KIRKLEES METROPOLITAN COUNCIL INVESTMENT & REGENERATION SERVICE

DELEGATED DECISION TO DETERMINE APPLICATIONS FOR NON-MATERIAL AMENDMENTS

Reference No: **2022/NM/92824/E**

Site Address: Former North Bierley Waste Water Treatment Works,
Oakenshaw, BD12 7ET

DRAWING NO: 2115 PL 134

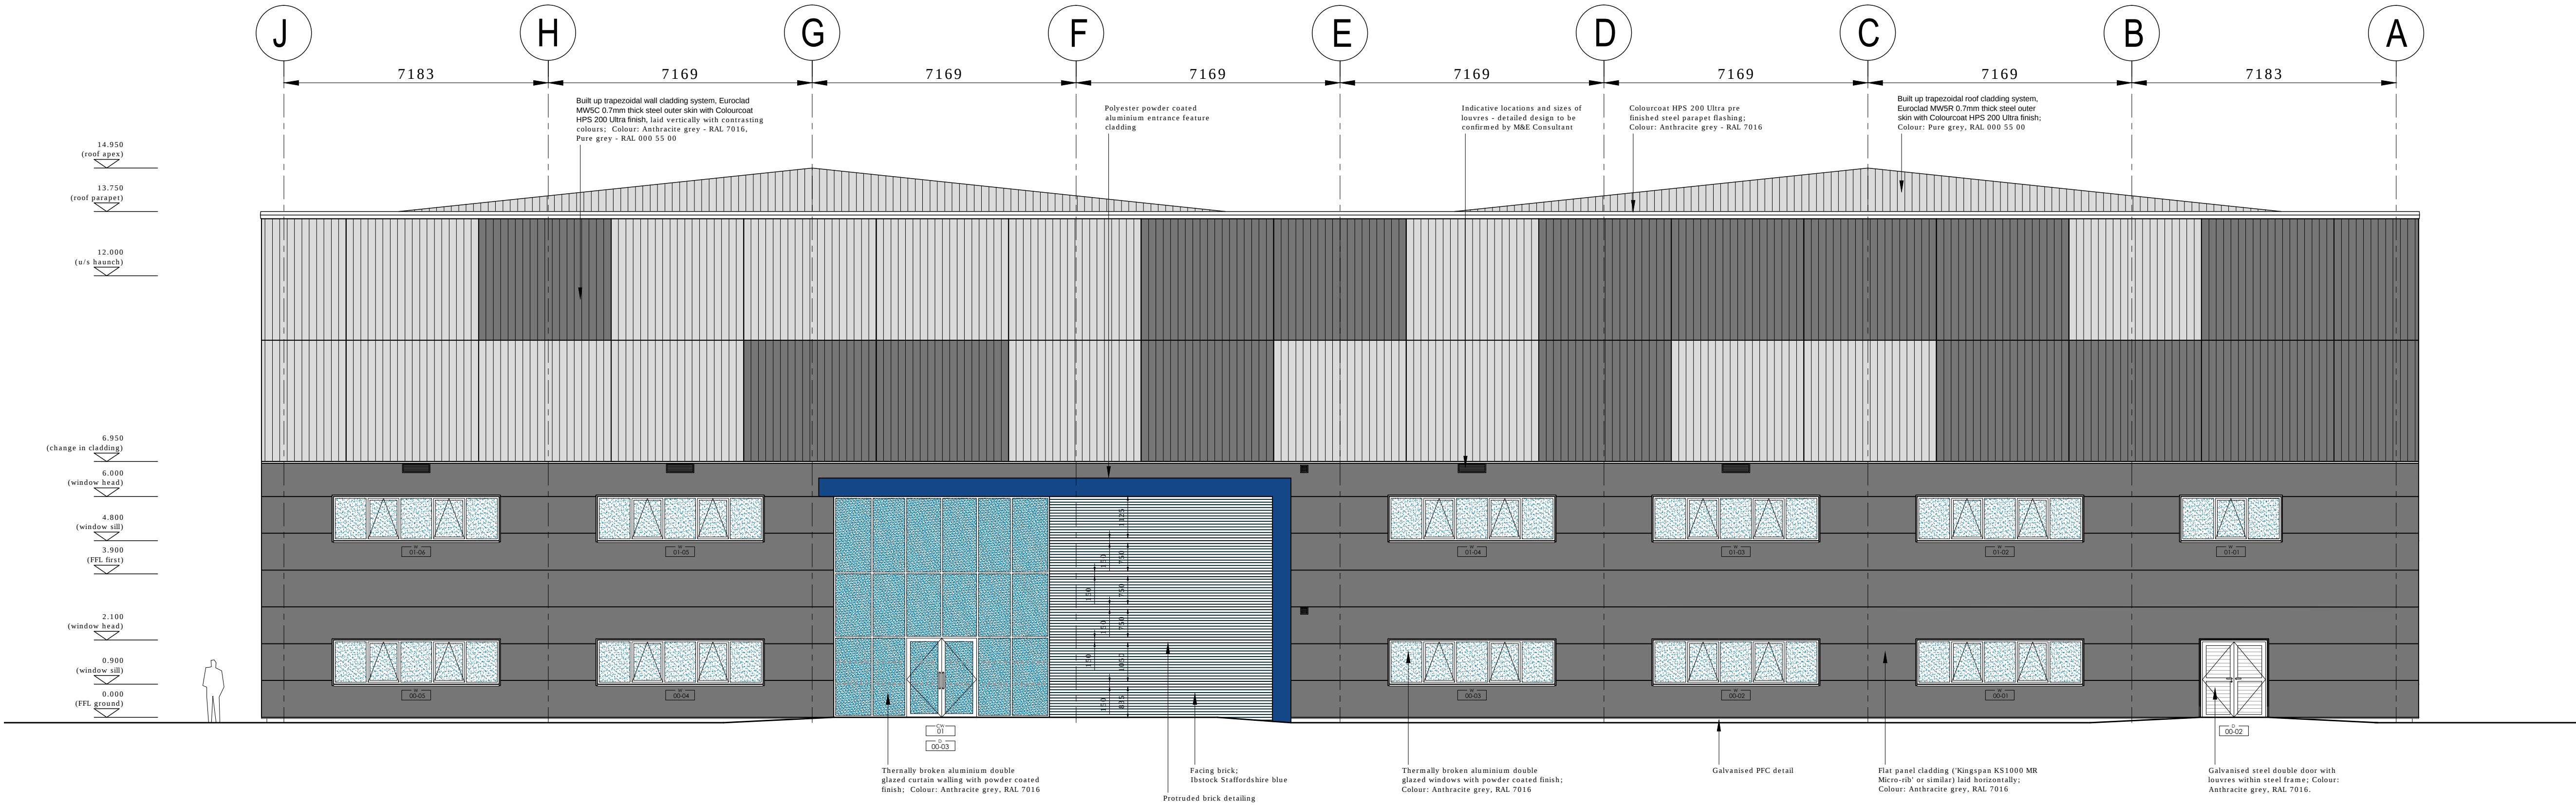
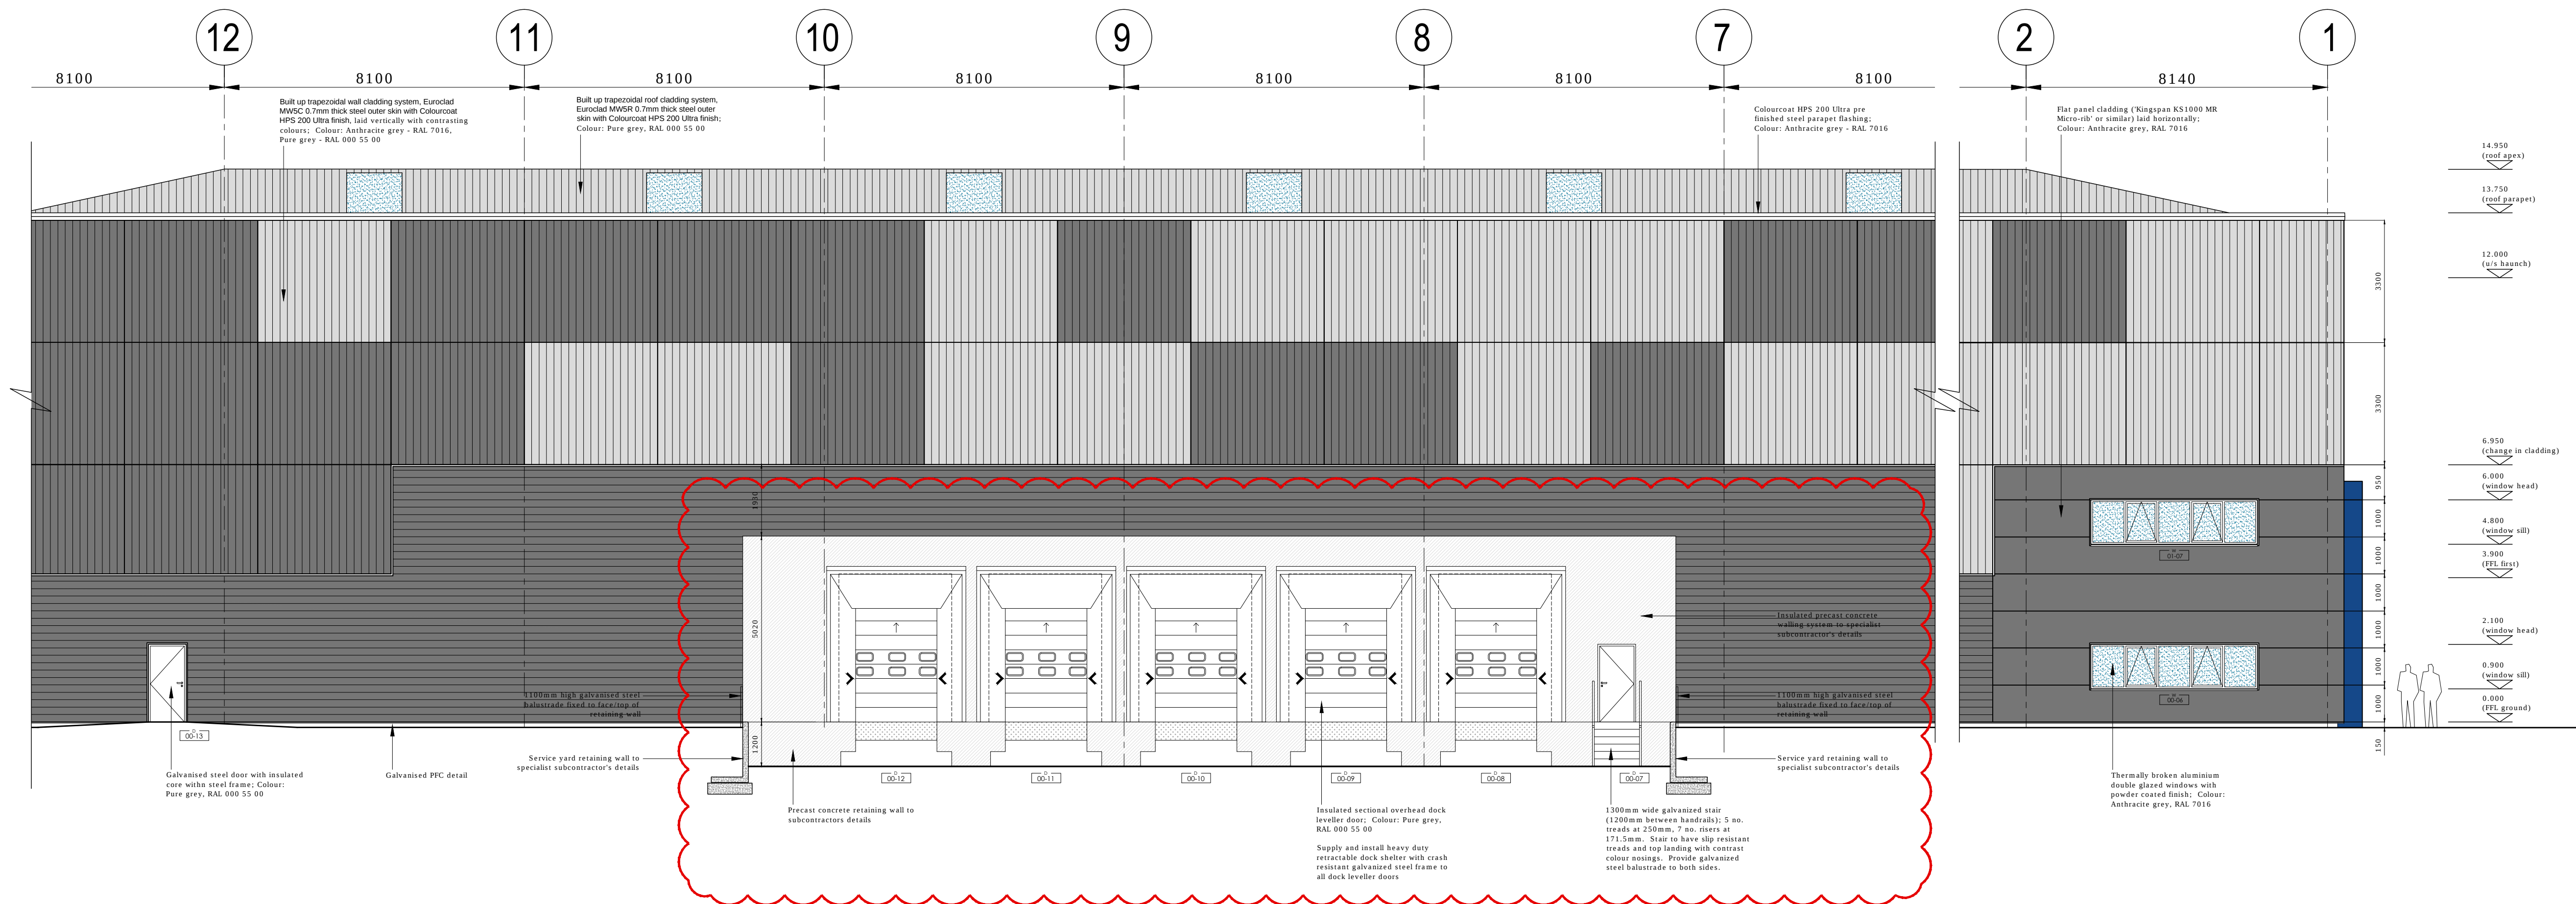
- Changes to elevations (changing brick surround of dock doors to insulated concrete).
-

The elevational changes are minor in nature. The change from brick to concrete covers a small area on each building. It is not expected to cause either buildings' appearance to be visually worse, nor materially different to the casual observer. Fundamentally these are utilitarian commercial buildings, and this appearance and character will be unaffected by the proposal.

- Changes to the ramps to the vehicle service bays.

The service bays would go from having ramped sides, to vertical flat sides. This change would not affect how vehicles access the vehicle bays, nor impact on their effective turning within the site. This is an operational change with minimal impact.
